## MEMORANDUM

**TO:** Jean Fraser, Planner  
**FROM:** David Senus, P.E. & Ashley Auger, E.I.T.  
**DATE:** October 12, 2012  
**RE:** 165 Presumpscot Street, Final Level II Site Plan Application

Woodard & Curran has reviewed the Final Level II Site Plan Application for the proposed improvements at 165 Presumpscot Street in Portland, Maine. The project consists of paving an existing gravel lot (an existing impervious surface) and associated drainage improvements. The proposed paved lot falls within the footprint of the existing gravel lot, and therefore the project does not propose to increase impervious area on the site. Overall, the project proposes a net decrease of impervious area of 64,430 sq ft.

DRAWING NO. **C-10**

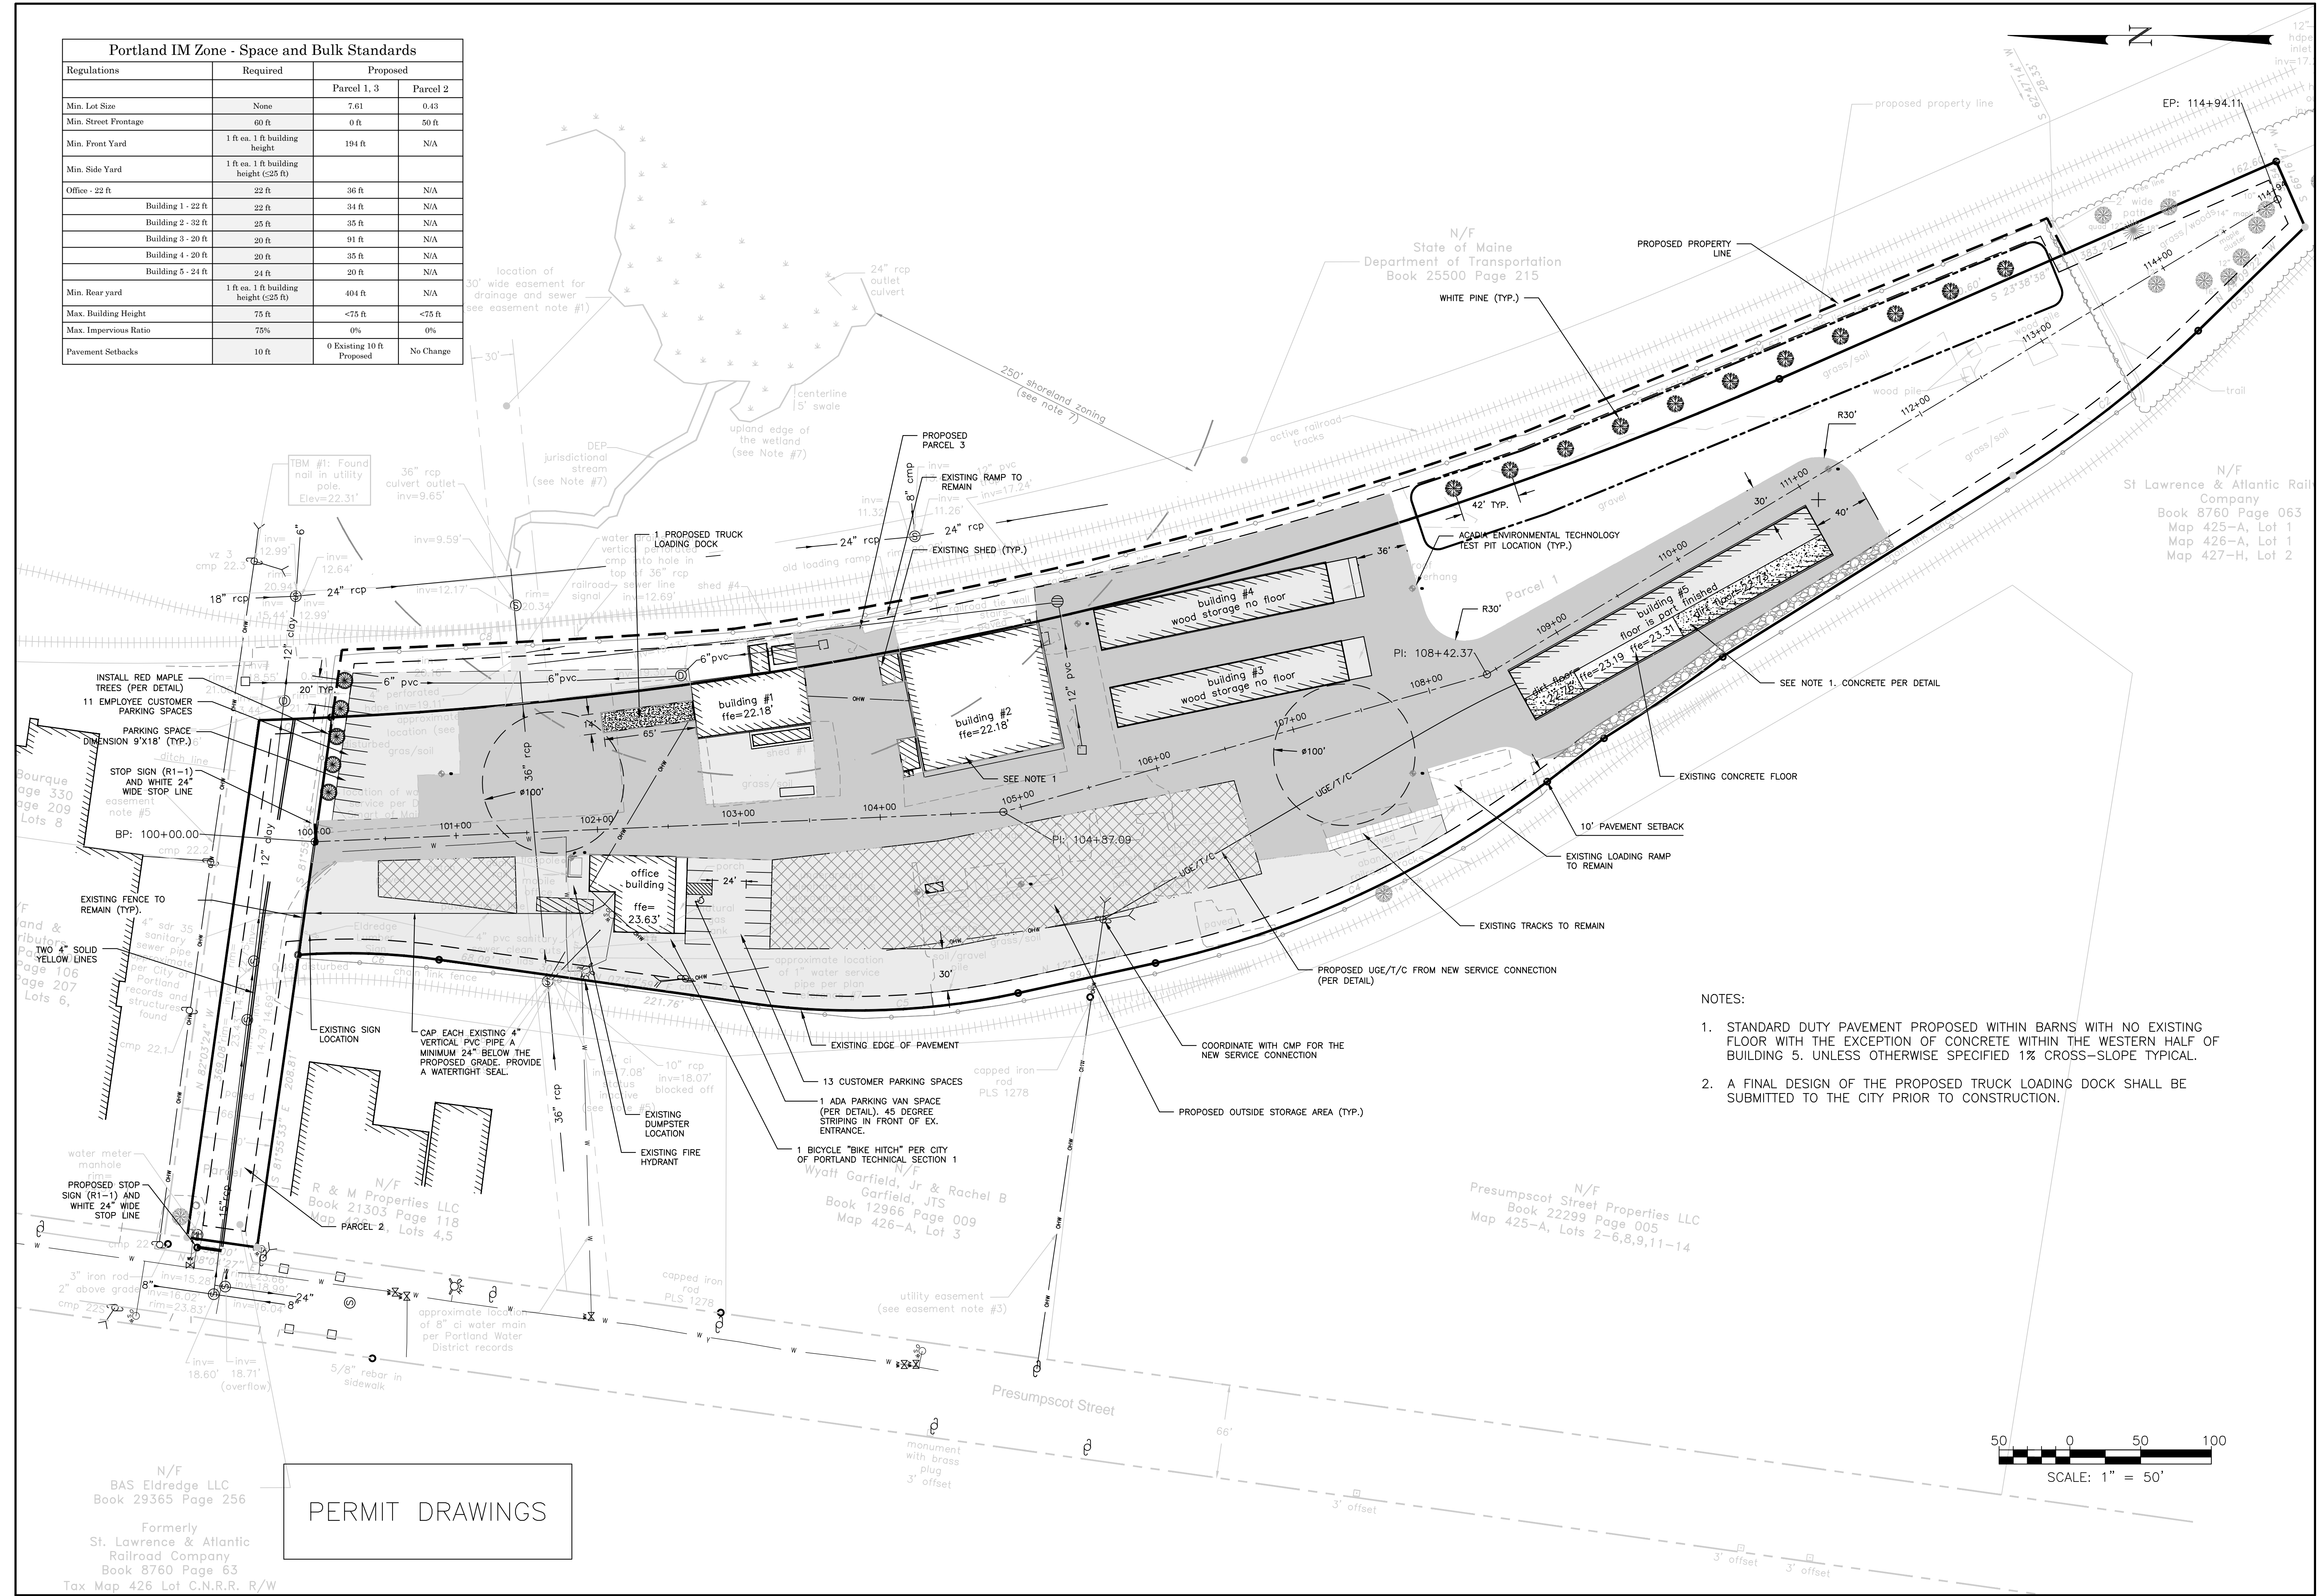
- 3) The applicant has indicated that an area of existing impervious gravel will be changed to grass, resulting in a net reduction in impervious surfaces on the site. The applicant should clarify the proposed grassed areas on the plan and should provide notes and information about the construction practice

that will be utilized to vegetate the site (removal of packed gravel, depth of loam, seeded areas, erosion controls as needed, including blanket lining at swales or steep slopes).

DRAWING NO. **C-20**

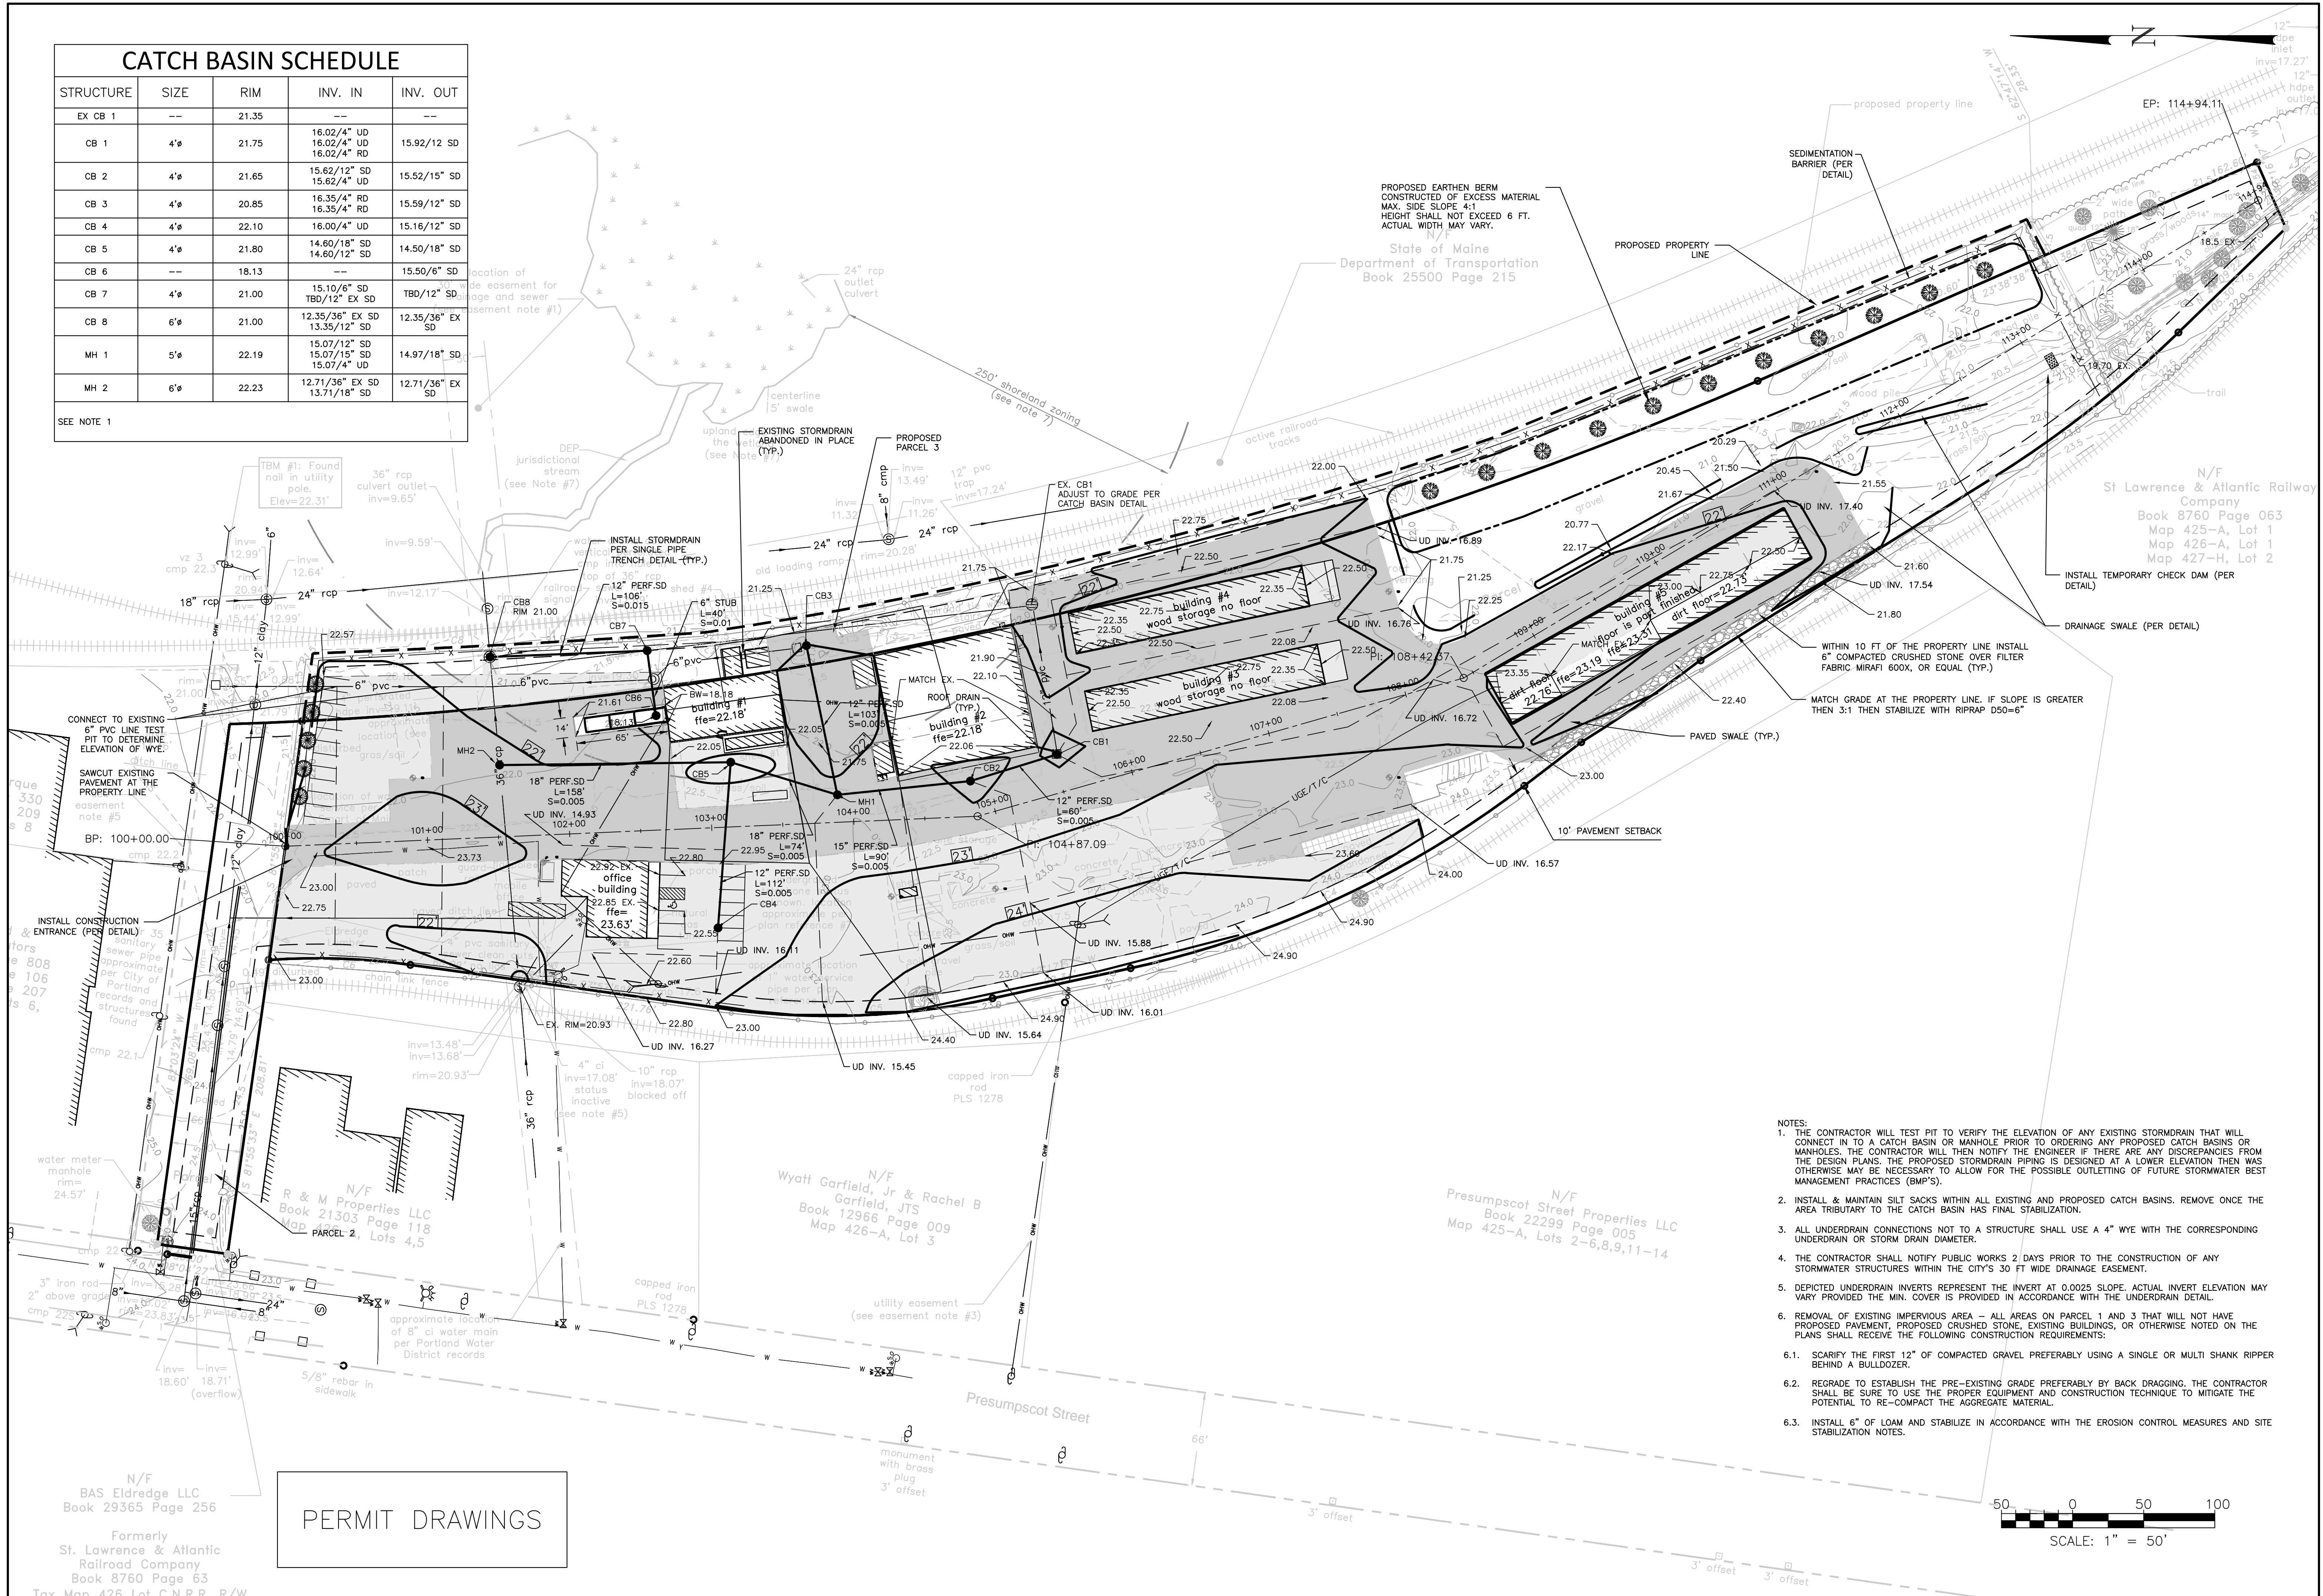
- 4) Sheet C-20 depicts a compacted gravel swale along the west edge of the site, adjacent to and parallel with the west wall of building #5. Concentrating flow over compacted gravel will result in erosion. We understand that the applicant is attempting to maintain a 10' pavement setback from the property line in this area, but we request the applicant propose an alternate surface (crushed stone) or alternate drainage concept in this area to avoid erosion.

- 2) The applicant is proposing two Inserta-T connections for new 12 and 18-inch storm drain pipes into an existing City-owned 36-inch RCP storm drain that crosses the site within a 30' wide easement. Per discussions with DPS, the applicant should utilize drain manhole(s) for these connections. A single drain manhole that allows for both connections would be acceptable; however, the applicant will need to verify that the pipe elevations and the configurations of the pipe penetrations can be accommodated by a single structure.
